RE: 6 West Mead, East Preston, BN16 2SL (REF.: R/225/17/CLE)

I would like to make the following comments regarding the above planning application.

26 OCTOBER 2007 13:49.

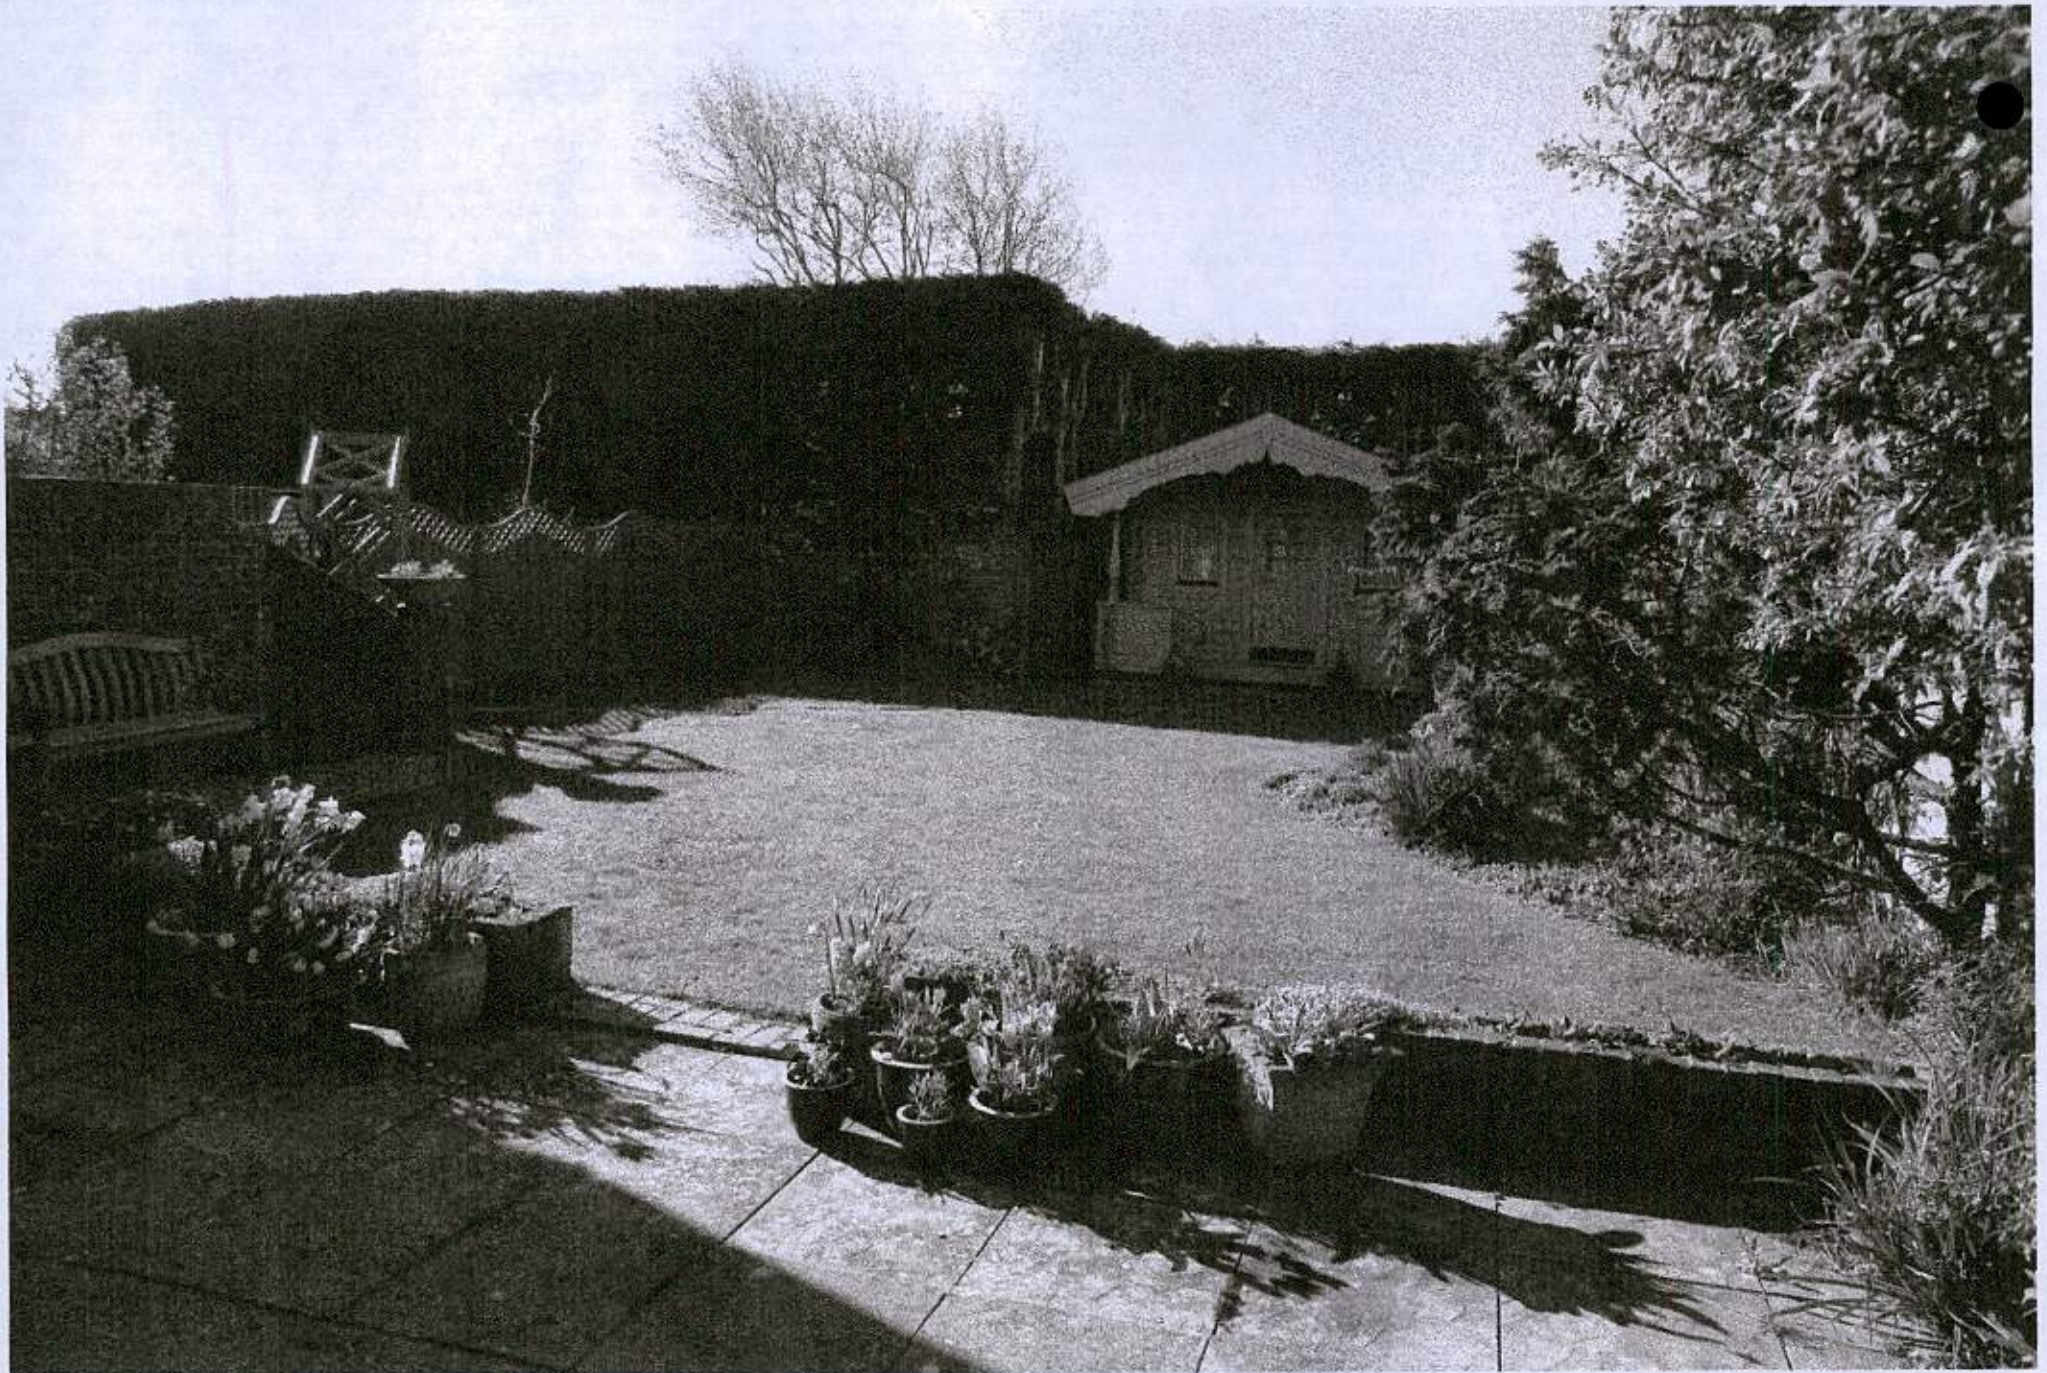
2. It can be seen from the third and fourth photographs that form part of the application (handwritten dates of 26 & 25th October 2007 respectively), that the boundary, before the building of the wooden structure was straight. The boundary has been moved and, we believe that this is because the roof of the wooden structure could not be accommodated within the bounds of 6 West Mead.
3. As you can see in the photographs above, the height of the existing wooden structure exceeds 2.5m. From the grounds of 5 West Mead, I would estimate the height to be approximately 2.9m and therefore well in excess of the permitted 2.5 metres.

Block Plan of Summer House

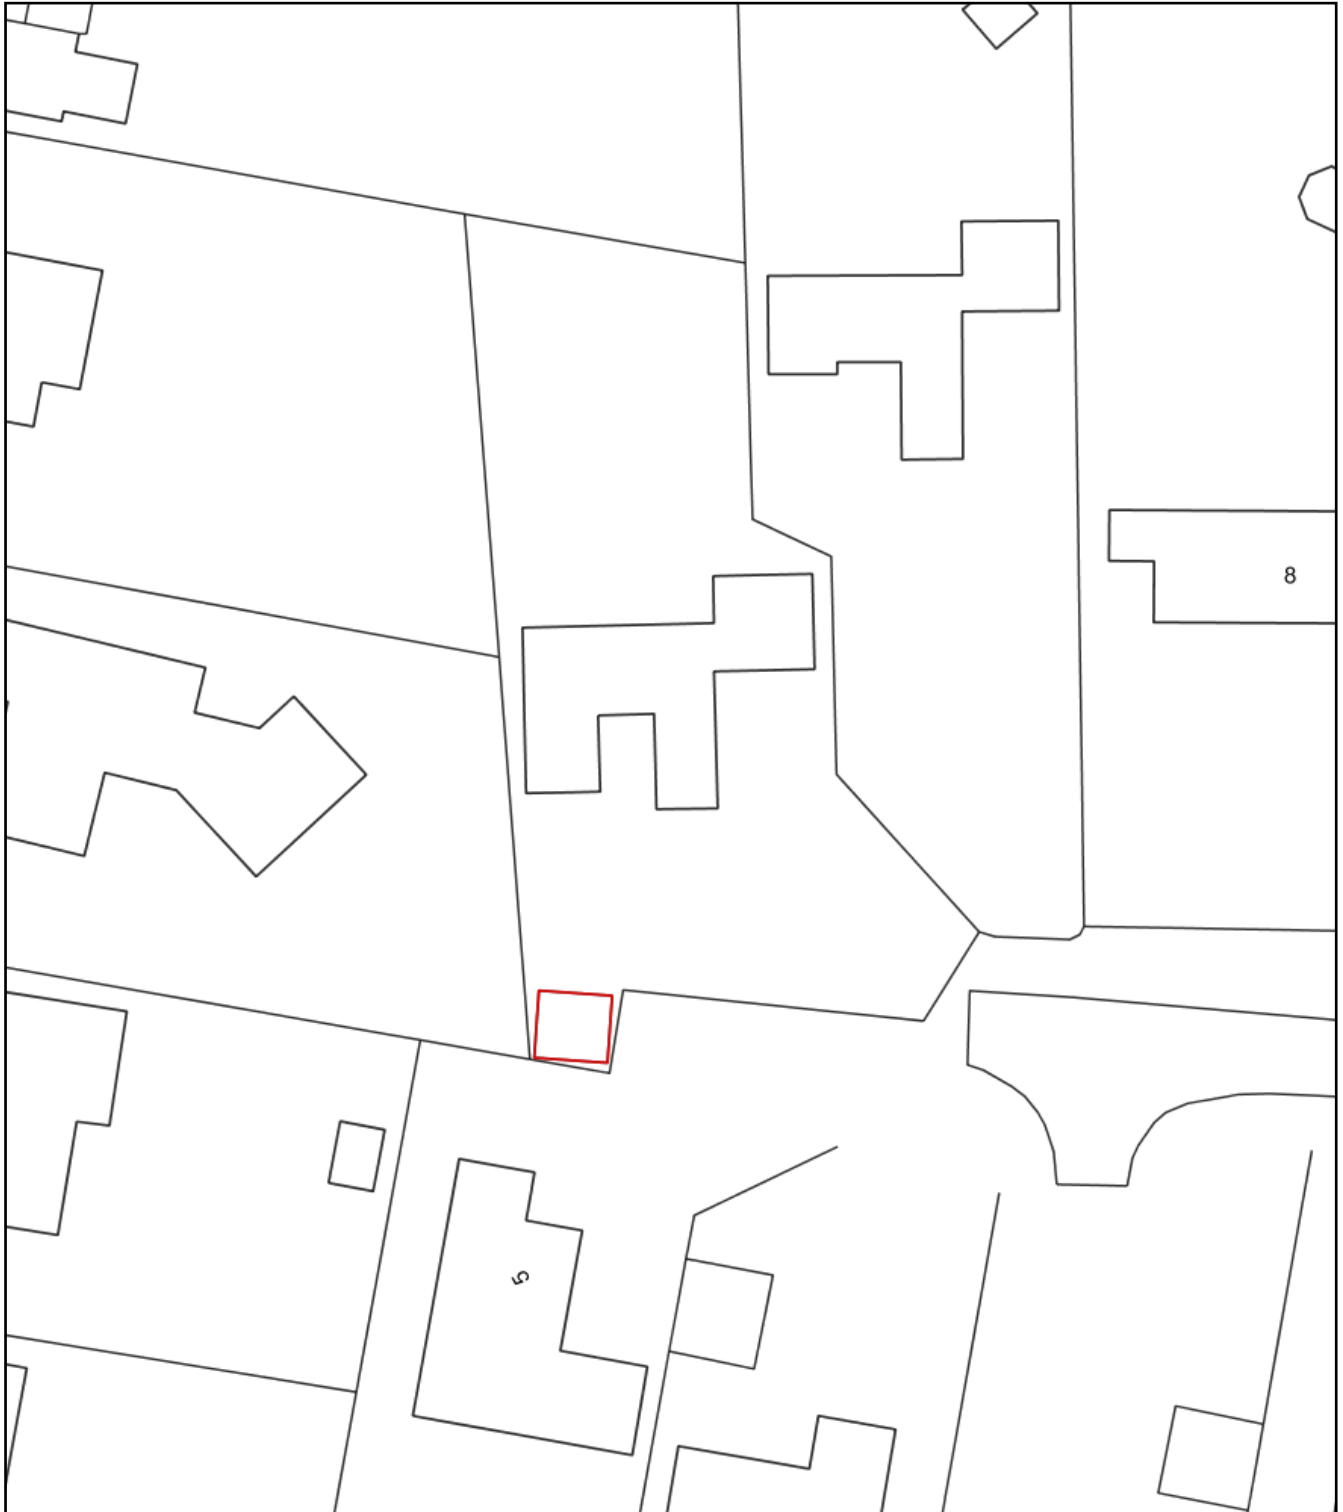
1. In the block plan contained in the application, the south boundary of 6 West Mead, where it adjoins the grounds of 5 West Mead is a straight line. In actual fact, the boundary is not a straight line. It 'steps' into the grounds of 5 West Mead by approximately 800 mm. It has been our contention that this represents a trespass. This is clearly shown in the photographs below. In addition, you will note that the position of the wooden structure is parallel with the boundary fences and not at an angle as shown in the block plan.
